March 5, 1979

Re: Terilynne Terrace Drainage Report

Re: Drainage Report for Terilynne Subdivision

GRADING PLAN

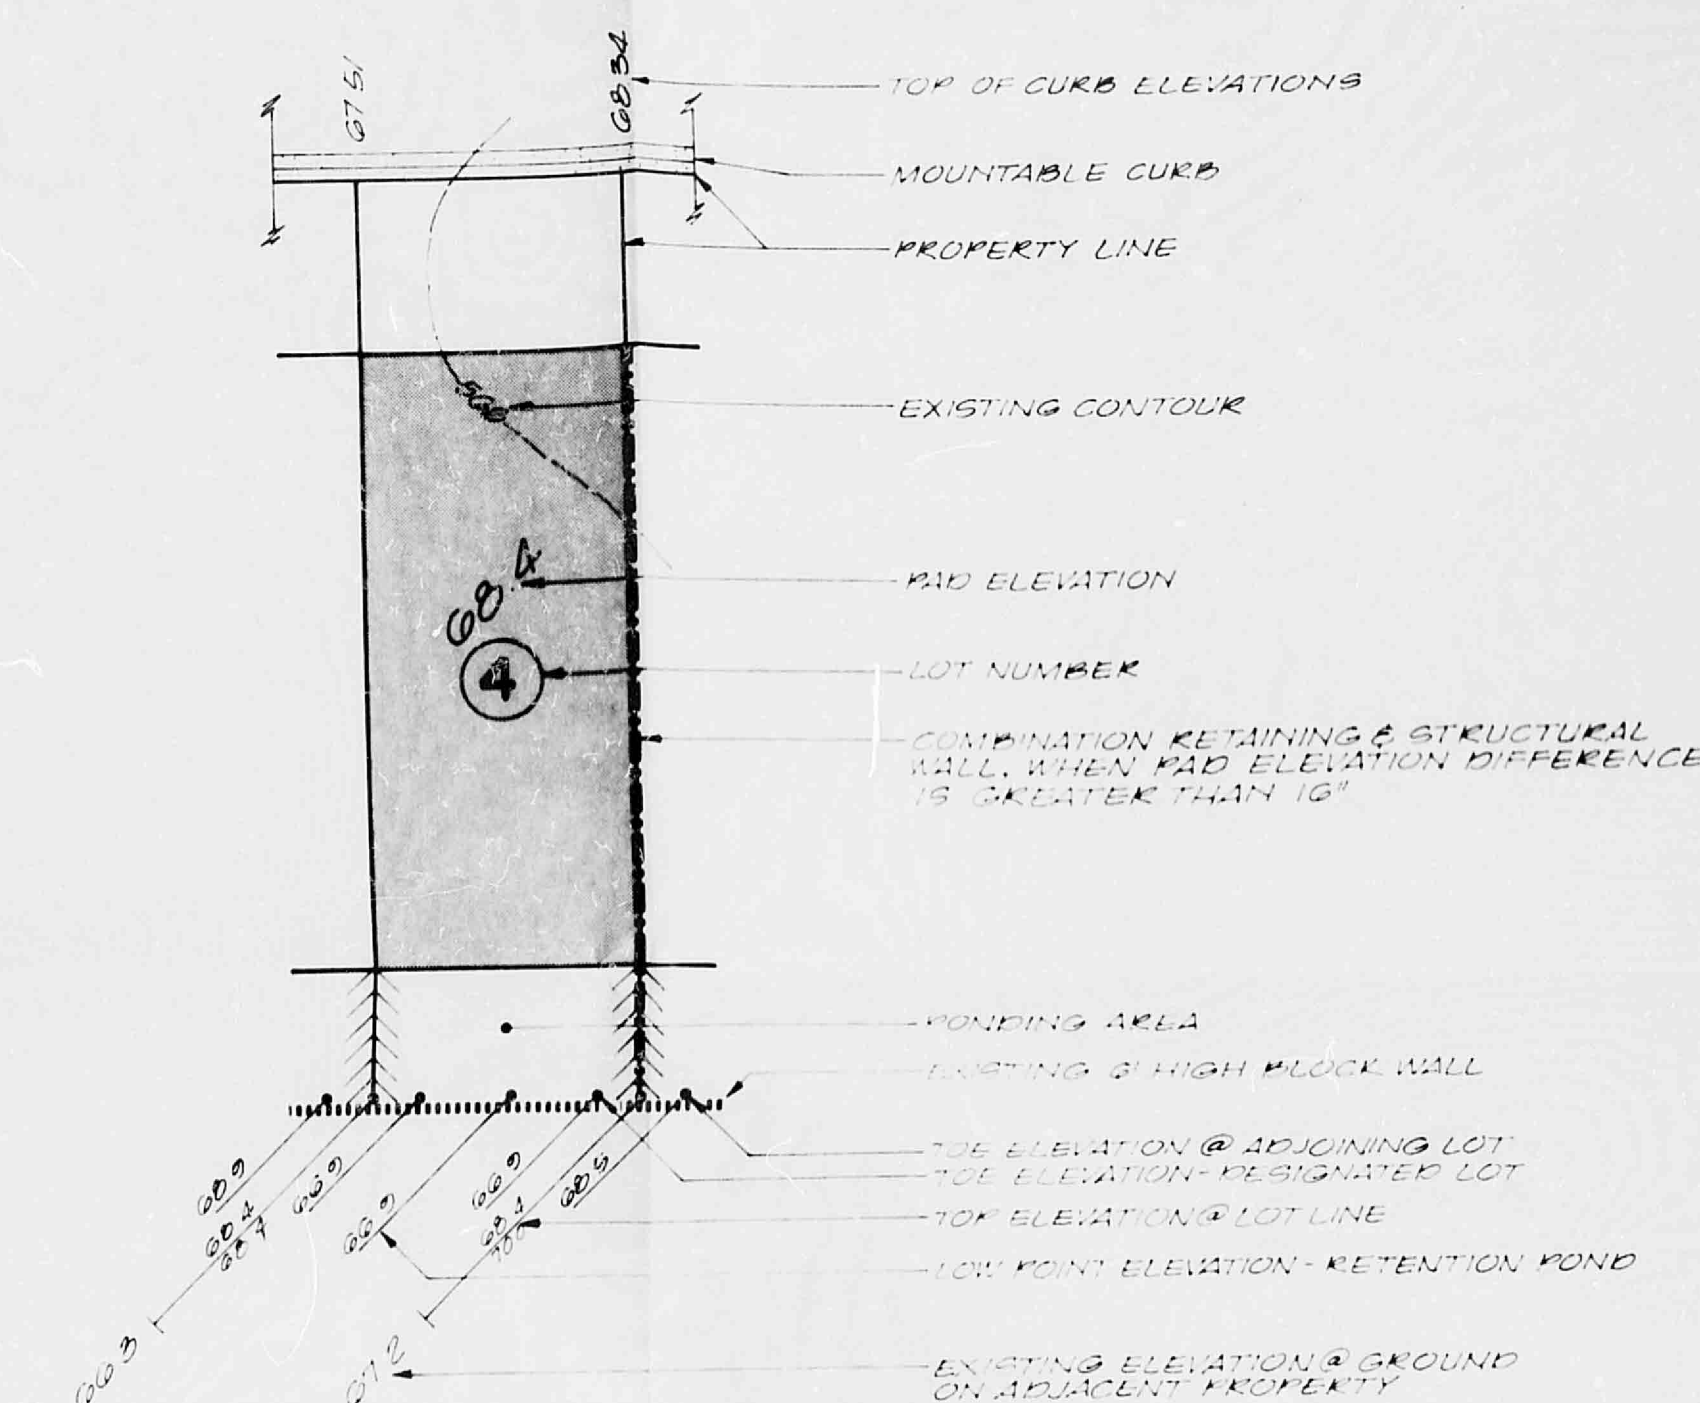
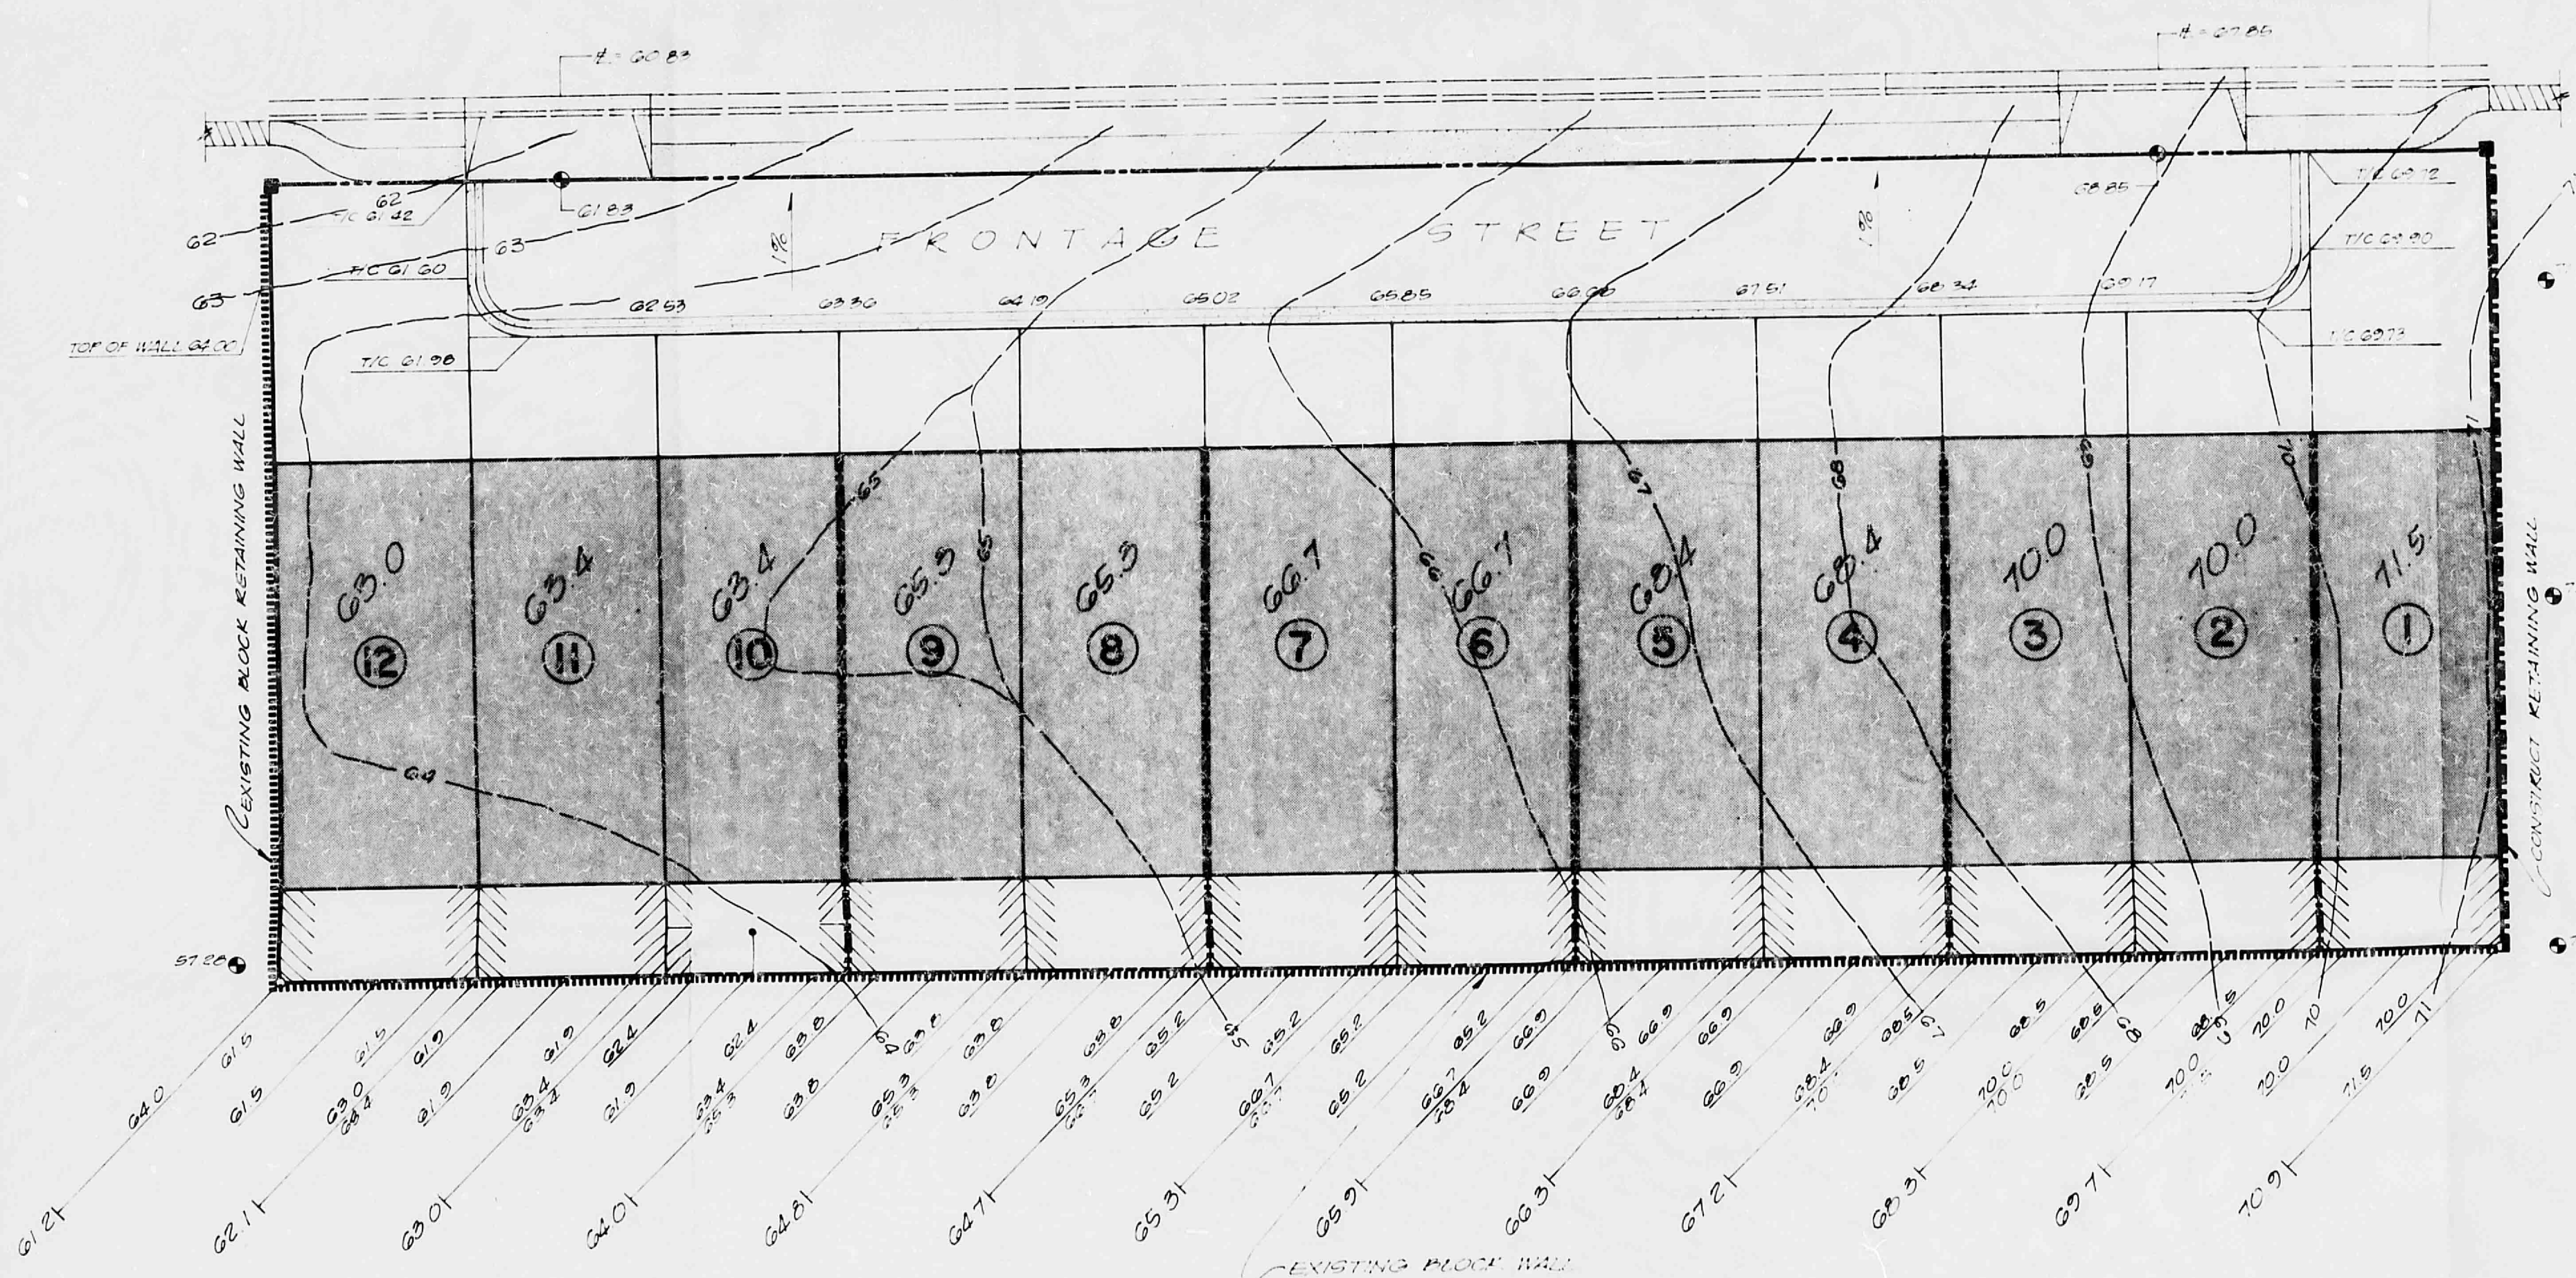
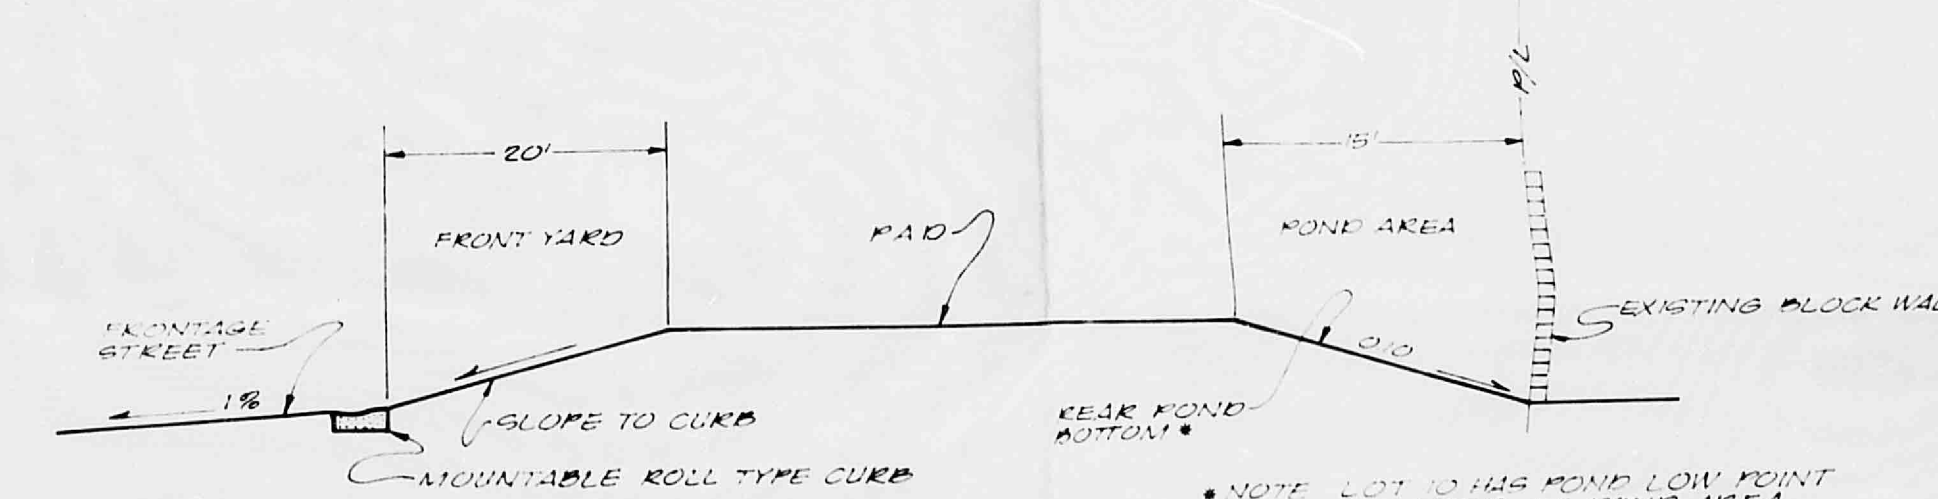
During the storm of August 10, 1963, excessive flooding is reported to have occurred in Candelaria Road. Even though protective facilities have been built since that date, and the residential pads proposed are elevated above the street level, an estimate of the 100 year water surface on Candelaria needs to be supplied with the drainage report. Regarding the internal provisions for drainage, I note that the elevations for the proposed retaining wall at the east property line are not given. Will the retaining wall prevent the natural runoff from the east to continue flowing through this property?

The grading plan also indicates that the runoff from the roof will accumulate against the garden wall to the south. What provisions will be made to prevent damages to the foundation and to the wall? The drainage report shows a detail of how the back yard ponding is supposed to be constructed. The same detail should be shown on the grading plan. I note also the ponding volume for the back yard ponds is computed using the procedure that makes allowance for the undeveloped runoff to exit the property. Since there is no way for the excess water to leave the property, the volume of the ponds must be adequate to handle 100% of the roof runoff.

It is my recommendation that a gravel trench be constructed in the ponding areas to supply the additional volume required and to remove from the back yards the runoff from the more frequent storms.

I received your letter dated February 27, 1979 concerning the drainage report for Terilynne Terrace. You indicated that a flow of 600 cfs could be expected in Candelaria Boulevard. My calculations indicate that a flow of 600 cfs would exceed the curb by approximately eight inches. This level would be below our pads and finished floors.

The property to the east of our project is already developed. All the asphalt is sloped to flow into Candelaria. Our project will not cut off any flows that could not go onto Candelaria.

With rear yards as some as these, water has to be ponded against the walls and foundations. Therefore, a note has been added to our drawings requiring the walls and foundations to be water proofed. Pond volumes have been increased to exceed a 100 percent retention.
